Marine
Management
Organisation

MMO Reference: DCO/2022/00007
Planning Inspectorate Reference: EN010125
Identification Number: 20050160

Planning Act 2008, RWE Renewables UK Dogger Bank South (West) Ltd and RWE Renewables UK Dogger Bank South (East) Ltd Proposed Dogger Bank South Offshore Wind Farms Order

Deadline 8 Submission

Title:
IHLS Temperature Data (2012)

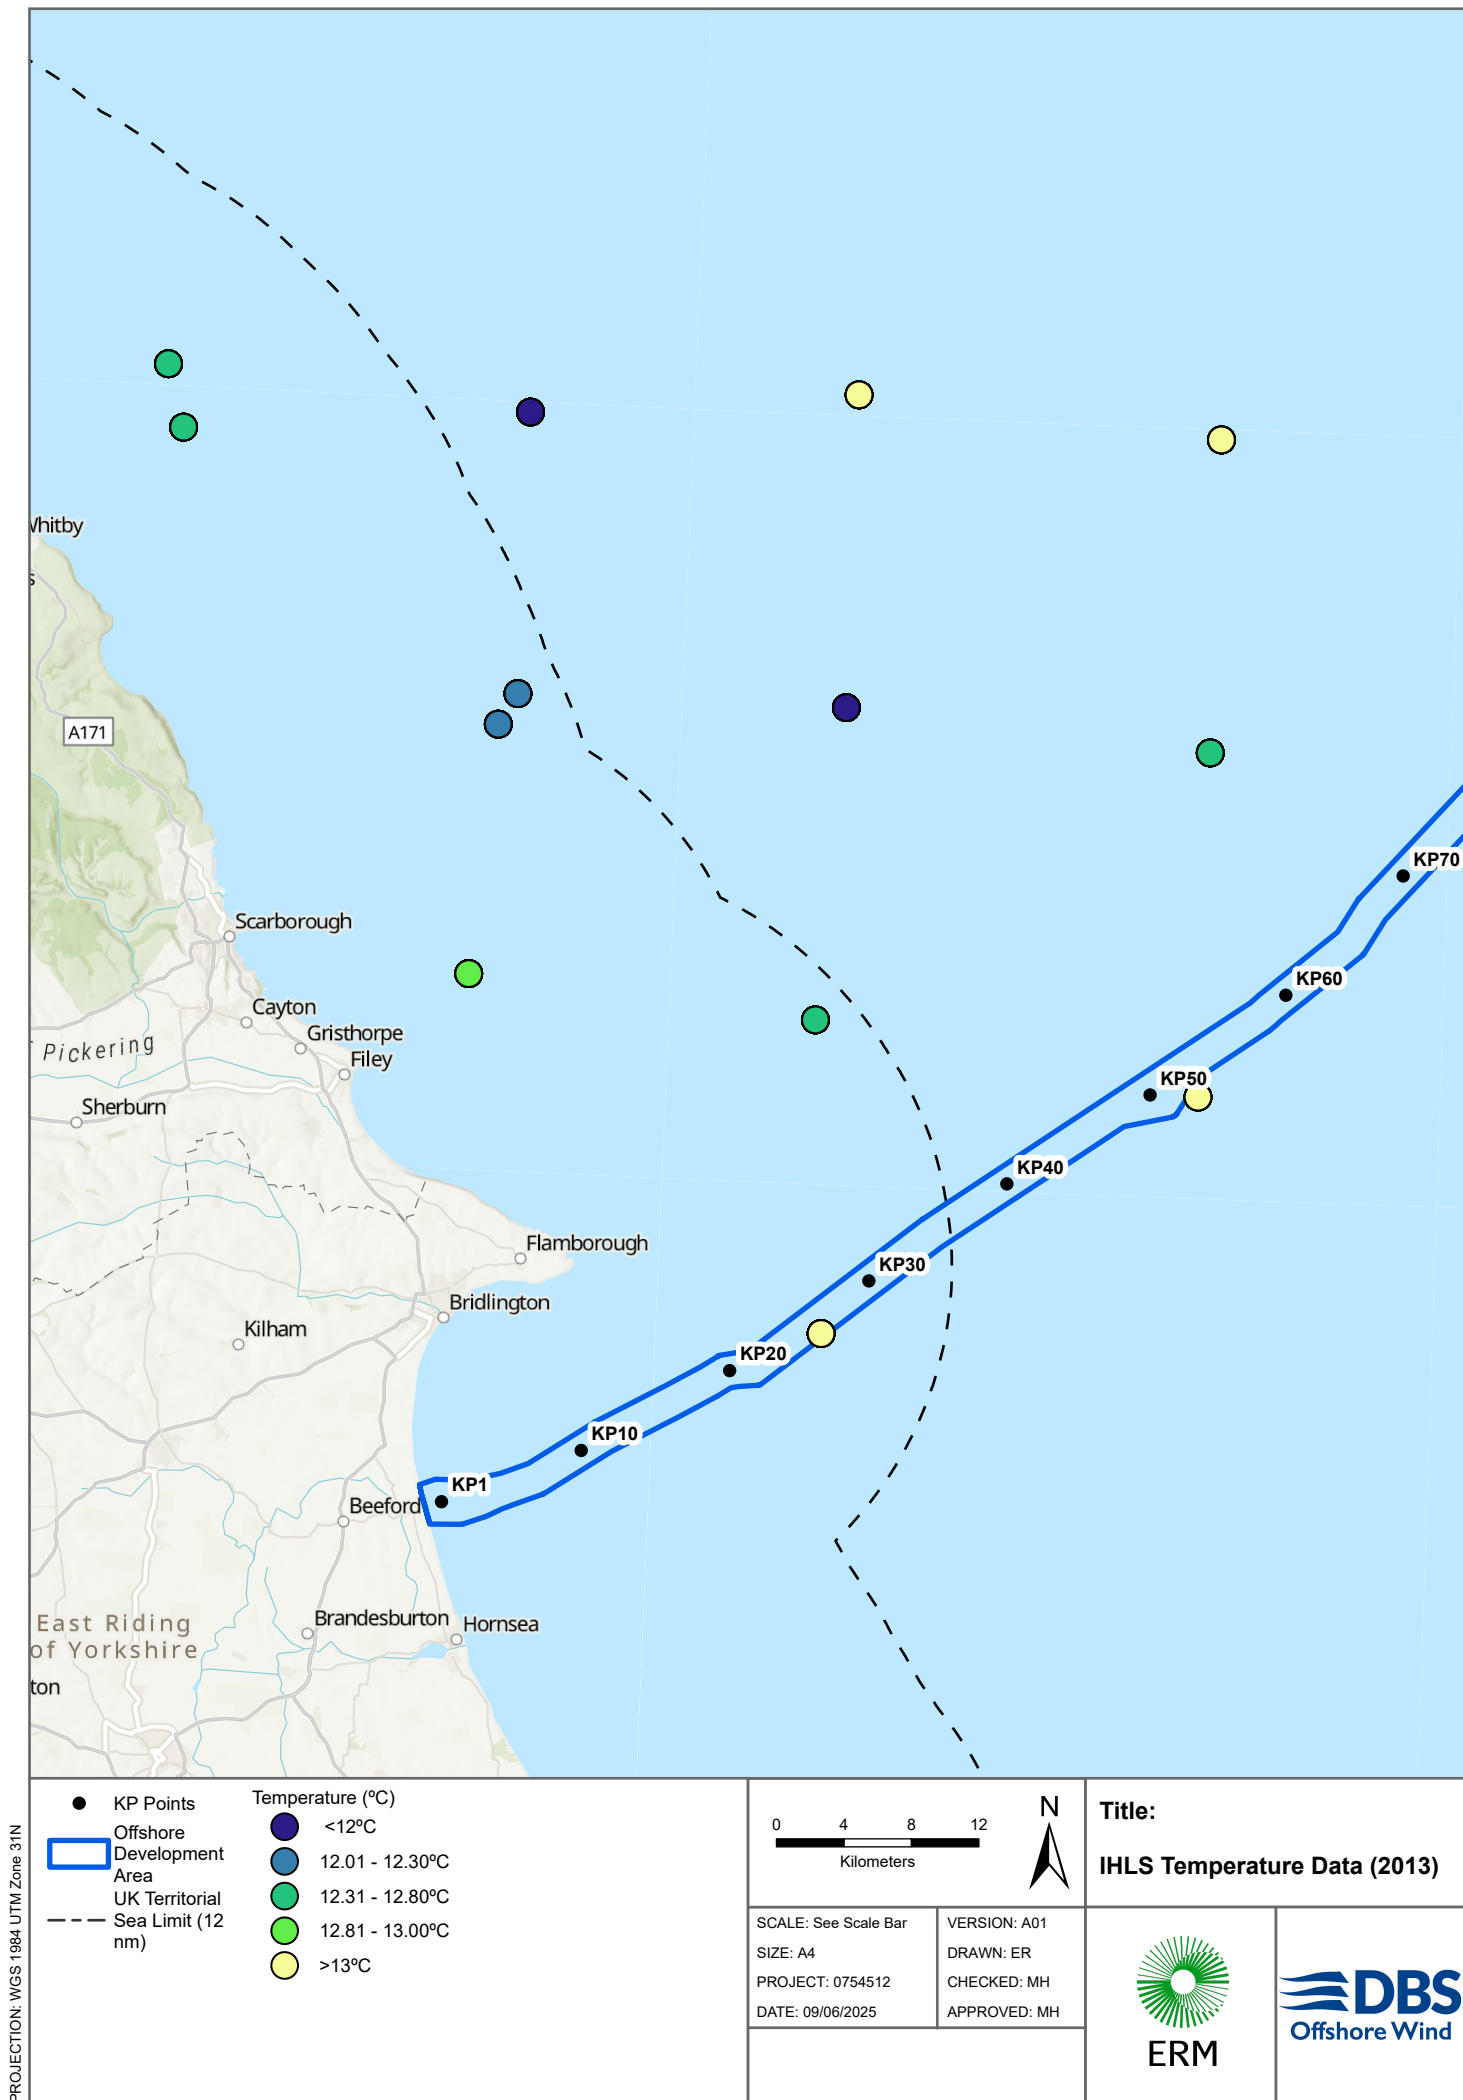
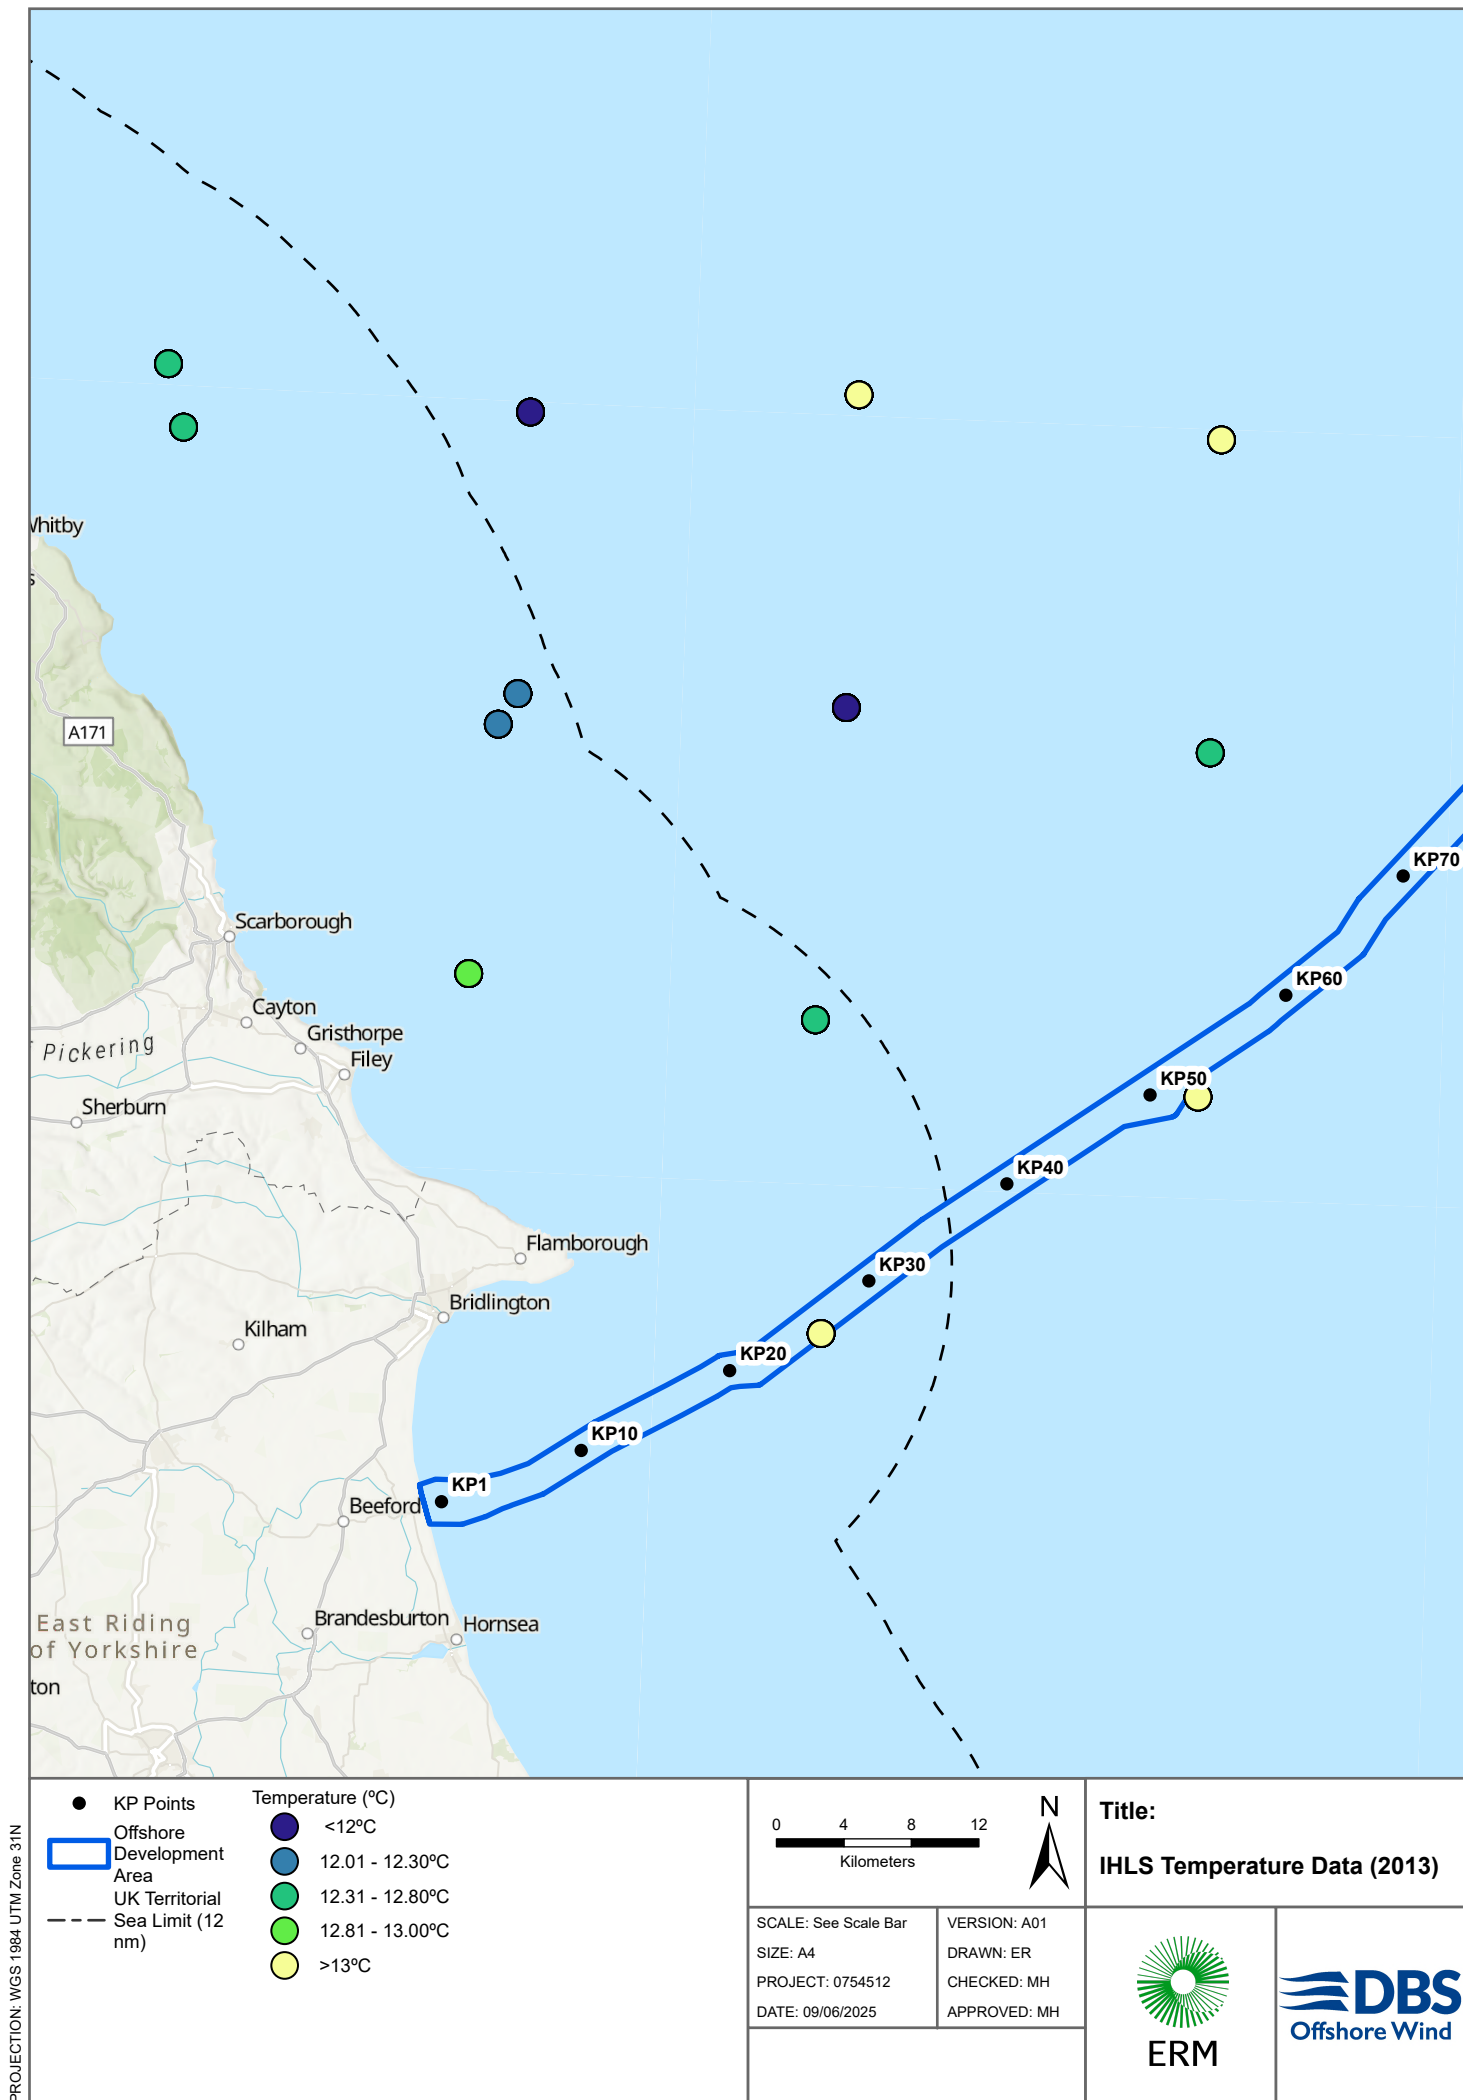
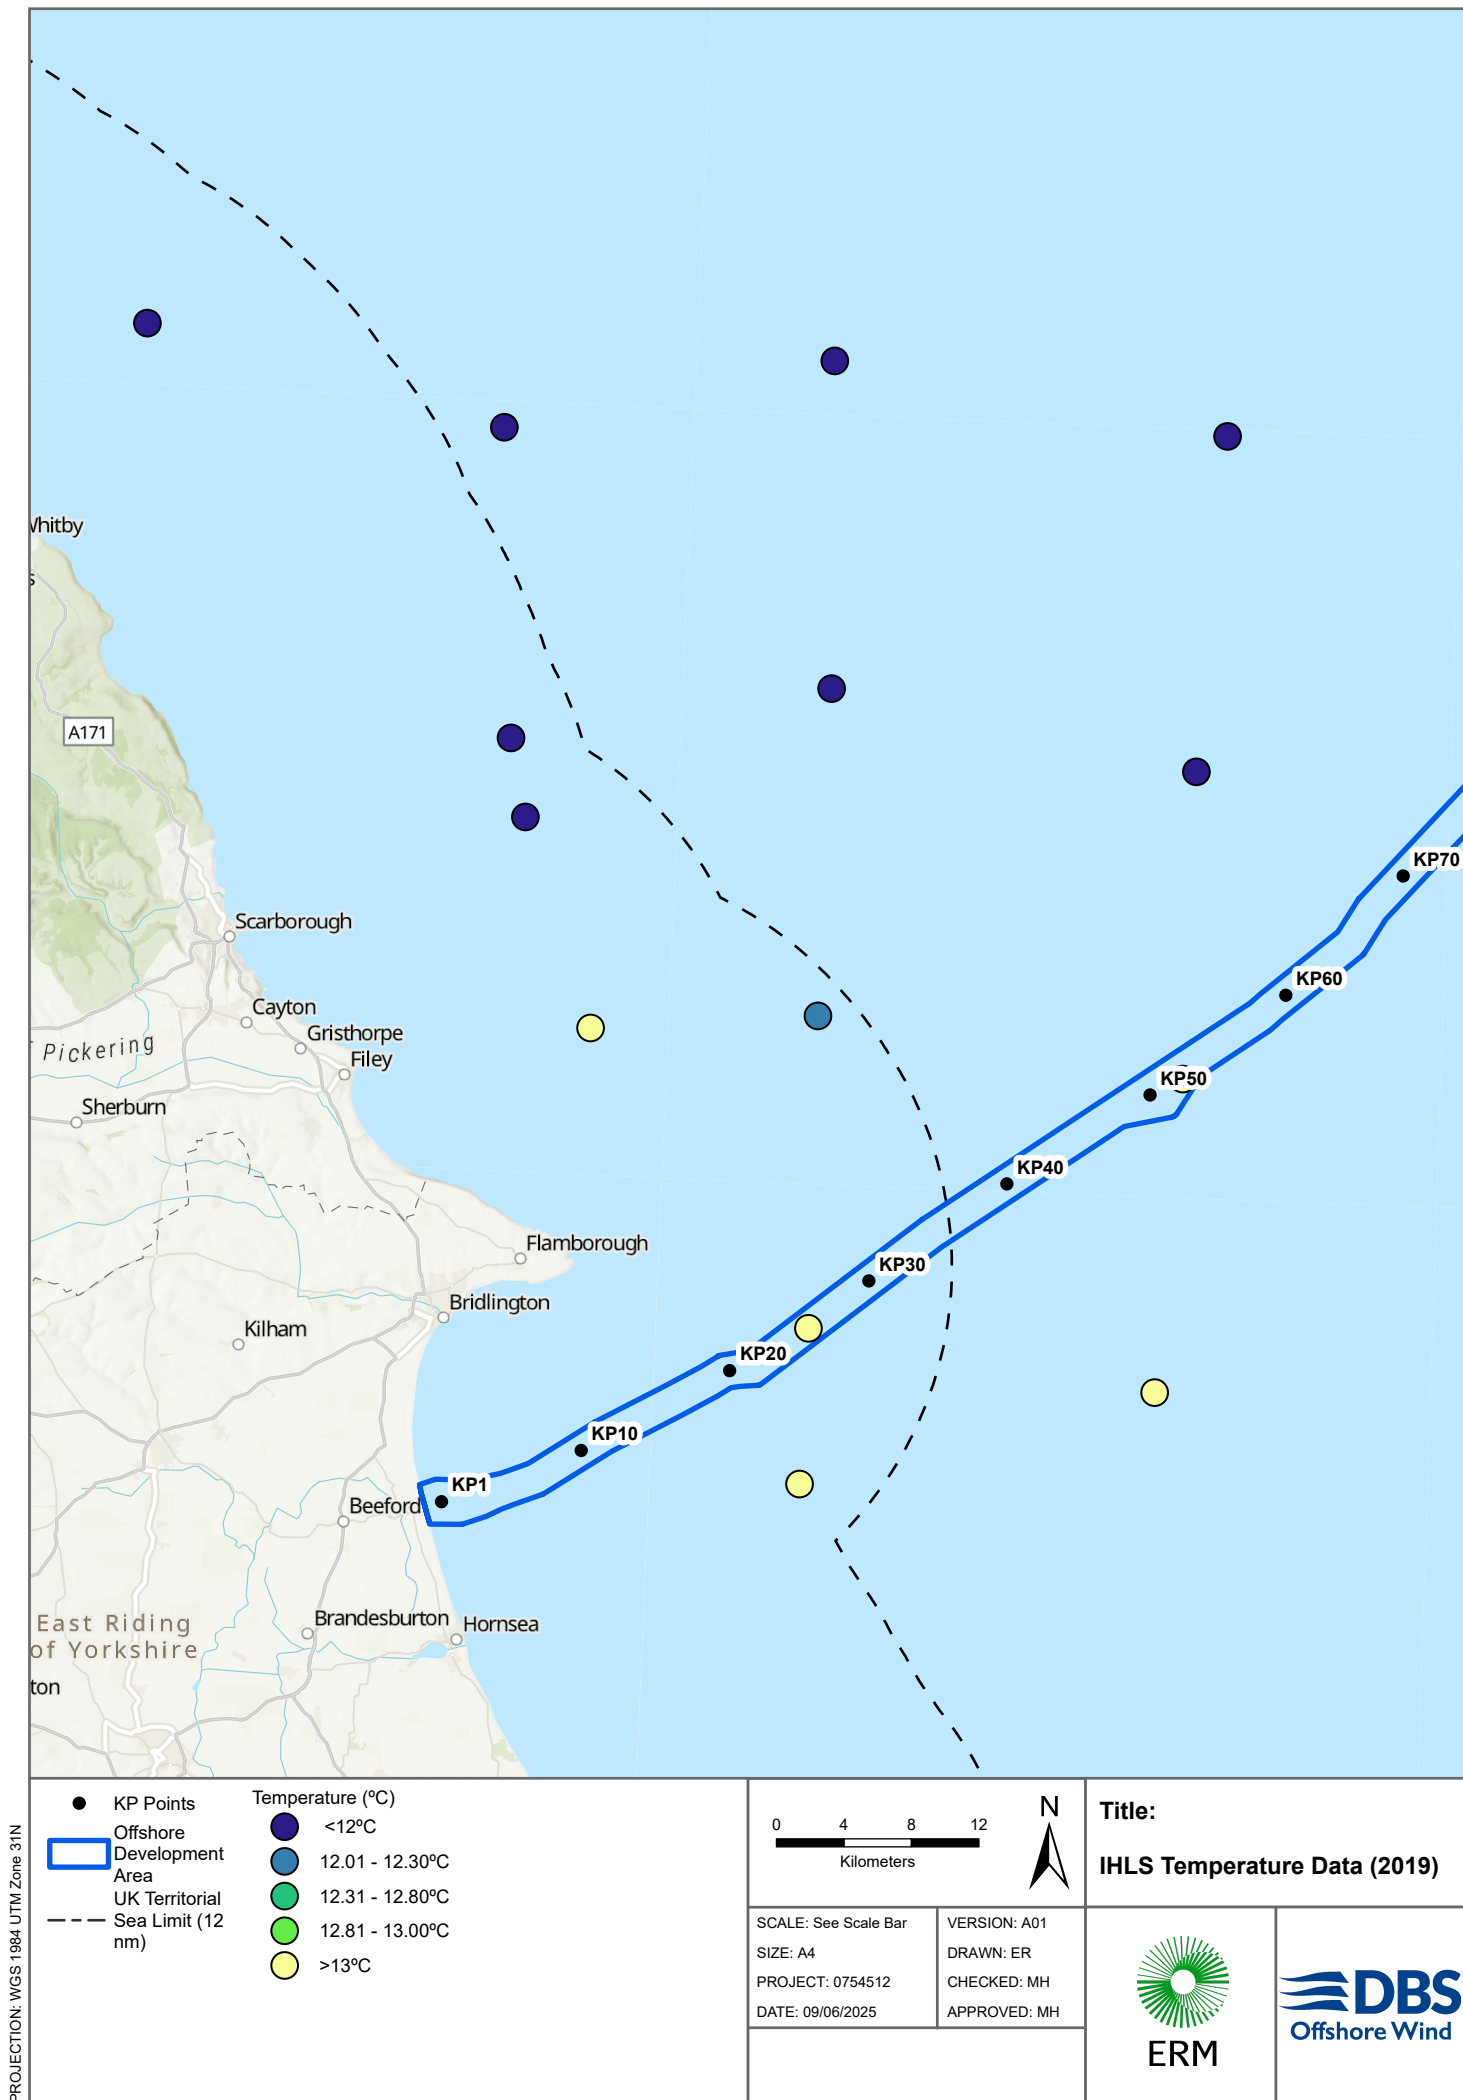
- 3.2.2 In Section 3.1, the Applicants state that "For the purposes of the back-calculation, the Offshore Export Cable Corridor is characterised by average temperatures >12.8°C". The near-seabed temperature data shows variation in near-bed temperatures for the International Herring Larvae Survey (IHLS) survey point within the ECC as being between 12°C Celsius (C) and >13°C, and the MMO does not believe that basing the back-calculation on average temperatures >12.8°C is appropriate as the data show periods where nearbed water temperatures have been lower than this, for example, temperatures of 12.01 - 12.30°C were recorded in 2012 and 2023.

To ensure that the Applicant's calculations are sufficiently conservative, the back-calculations should be based on near-bed water temperatures of between 12°C – 12.3°C as these are the lowest near-bed temperatures provided by the time series.
